RE: S75W MODIFICATION FOR WOLLONGONG PRIVATE HOSPITAL

1. As requested, we have reviewed the RMS response (22 August 2013) to the S75W to the approved Wollongong Private Hospital development. RMS has raised the following traffic matters:

TRUE NORTH	Drawn	Checked	Date	Scale
	CQ	HMC	03.06.13	1:500 @ A3
PROJECT NORTH	Drawing Title PLAN - LEVEL 1

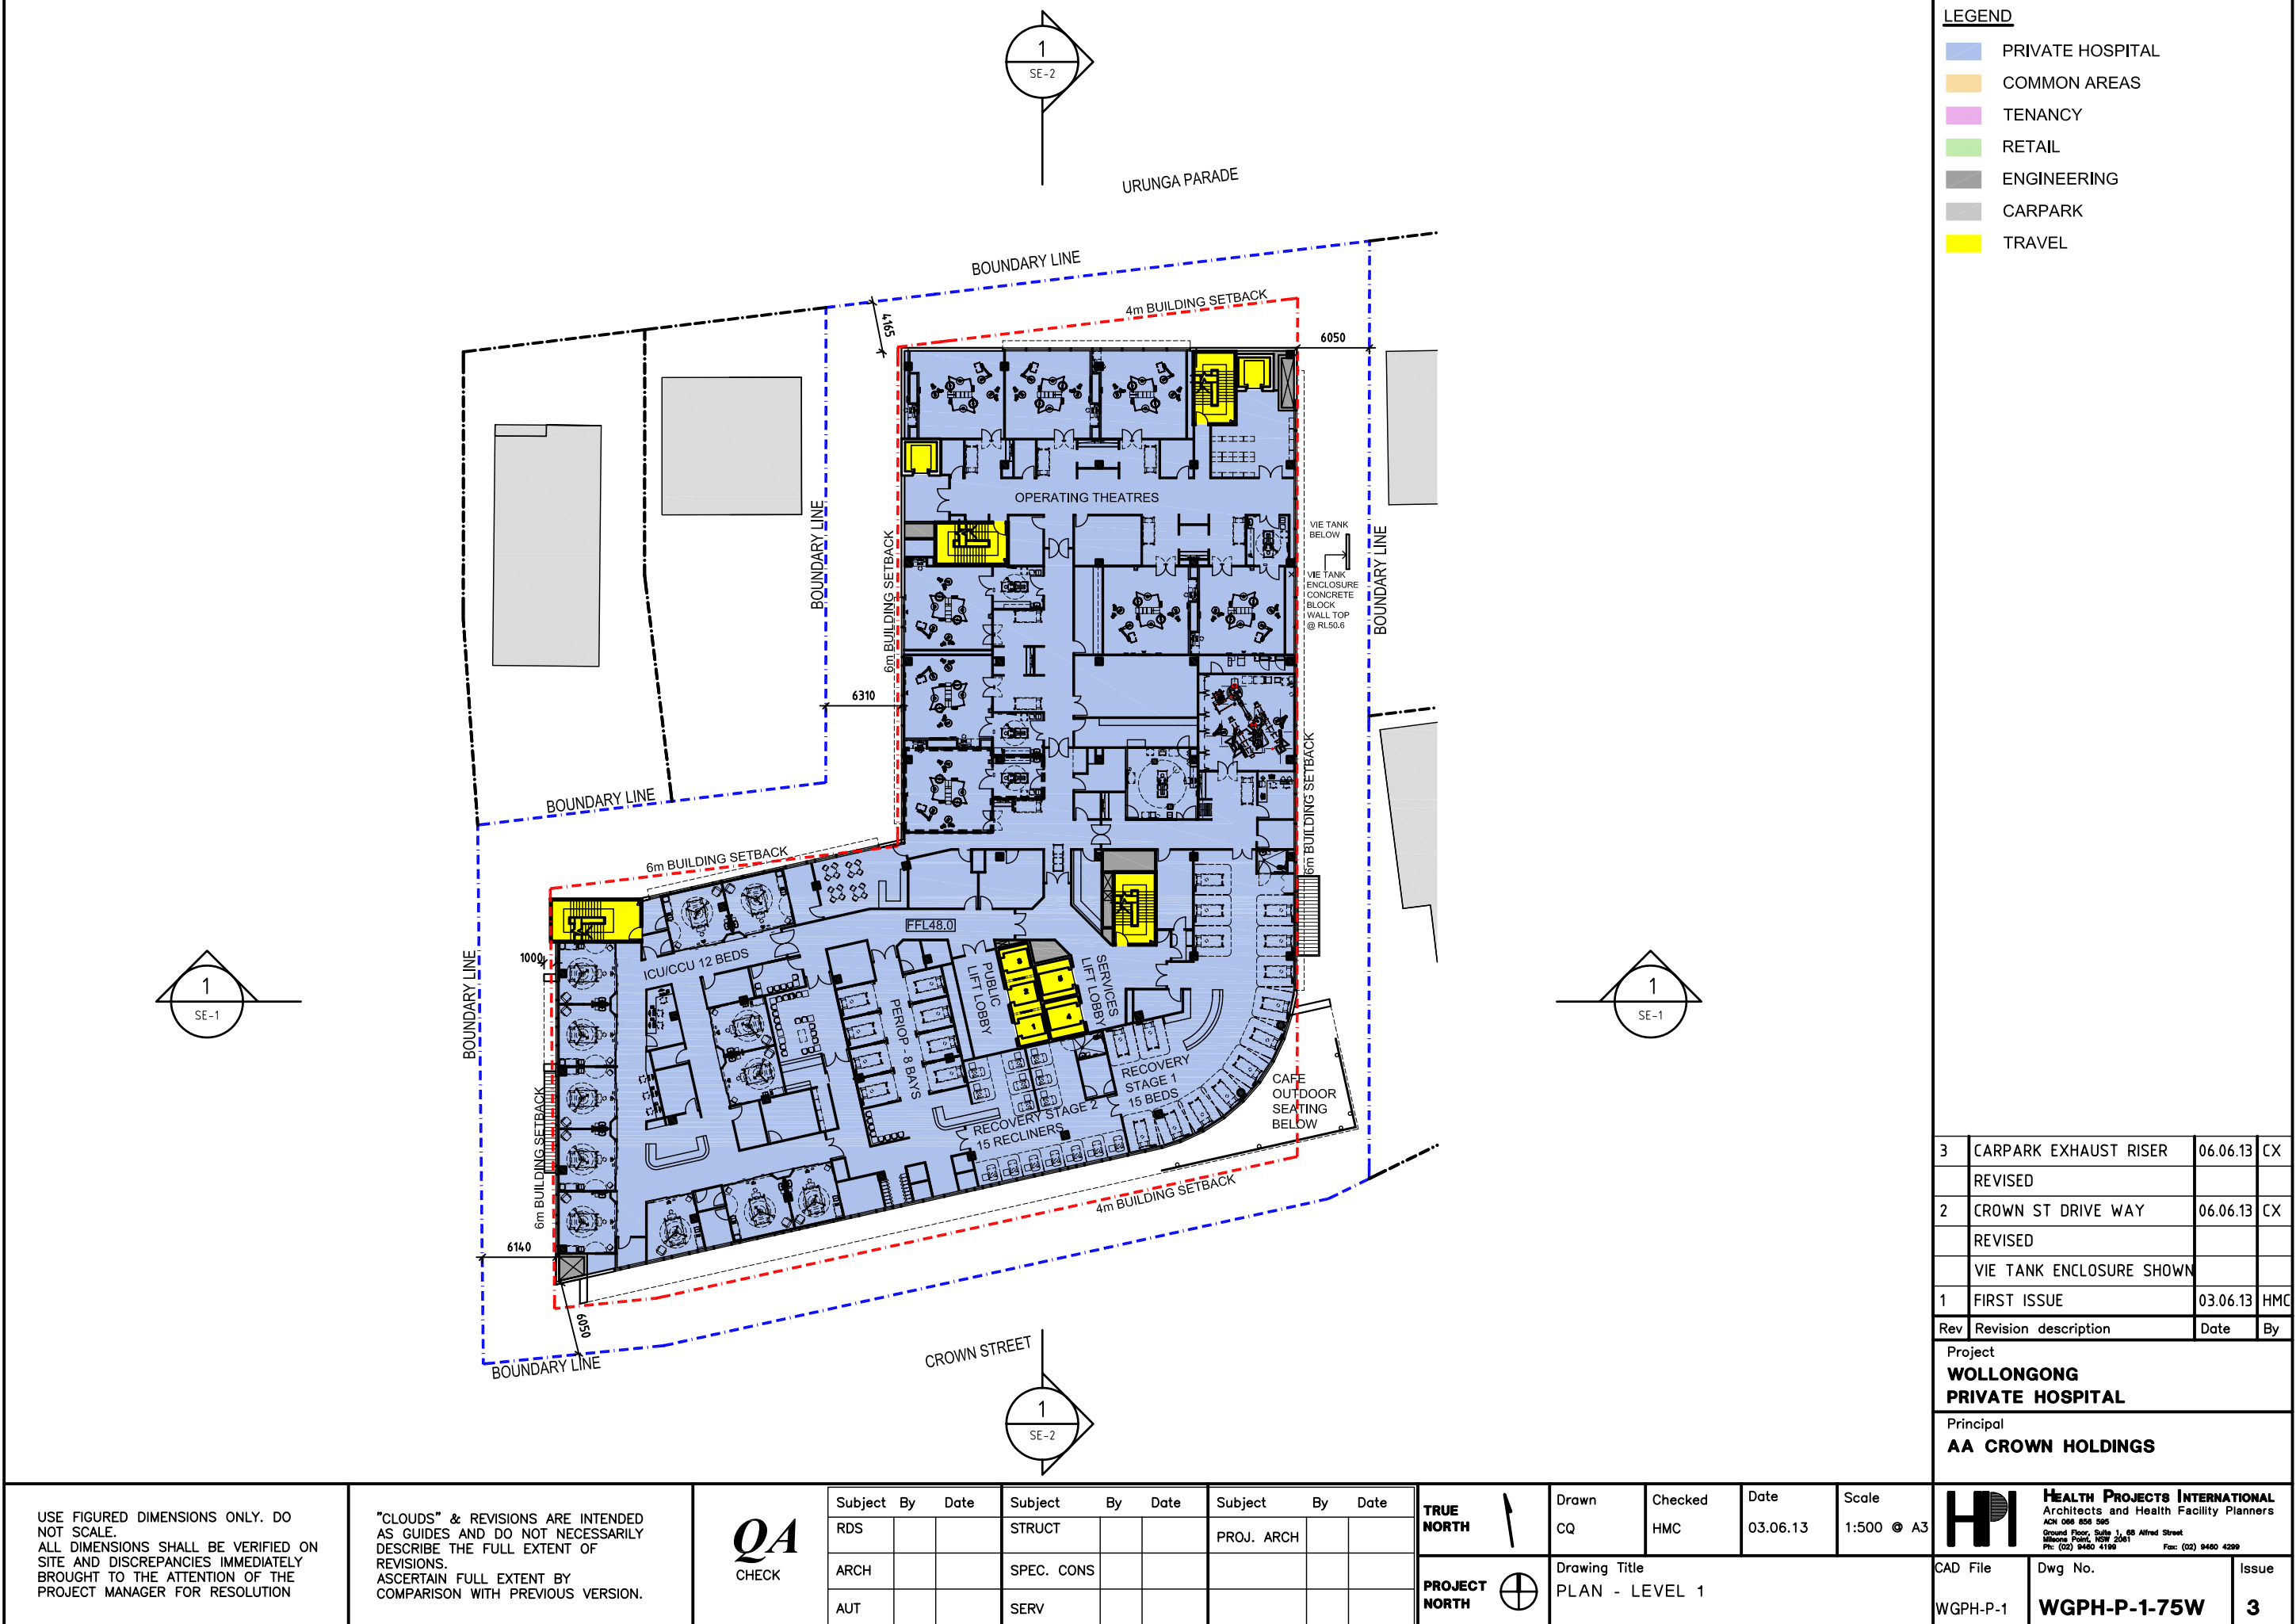
- The RMS does not support the deletion of the car park ingress from Urunga Parade; and
 - The RMS has raised concerns regarding the revised layout of the Crown Street access. In particular the limited approach distance to the traffic signals will affect "loading" of the traffic signals and may result in queuing for vehicles exiting the site.

6. At the Crown Street access the approach to the traffic signals for vehicles exiting the site has been widened to provide two traffic lanes for a distance of some 20 metres. This would allow at least six cars to queue within the two lanes. The widening of the approach would increase the “loading” of the traffic signals and hence reduce the potential for queuing within the site. This modification addresses the second matter raised by RMS. In addition the single non-disabled space located on the Crown Street level has been designated as parking for doctors/emergency vehicles only (rather than general public parking).
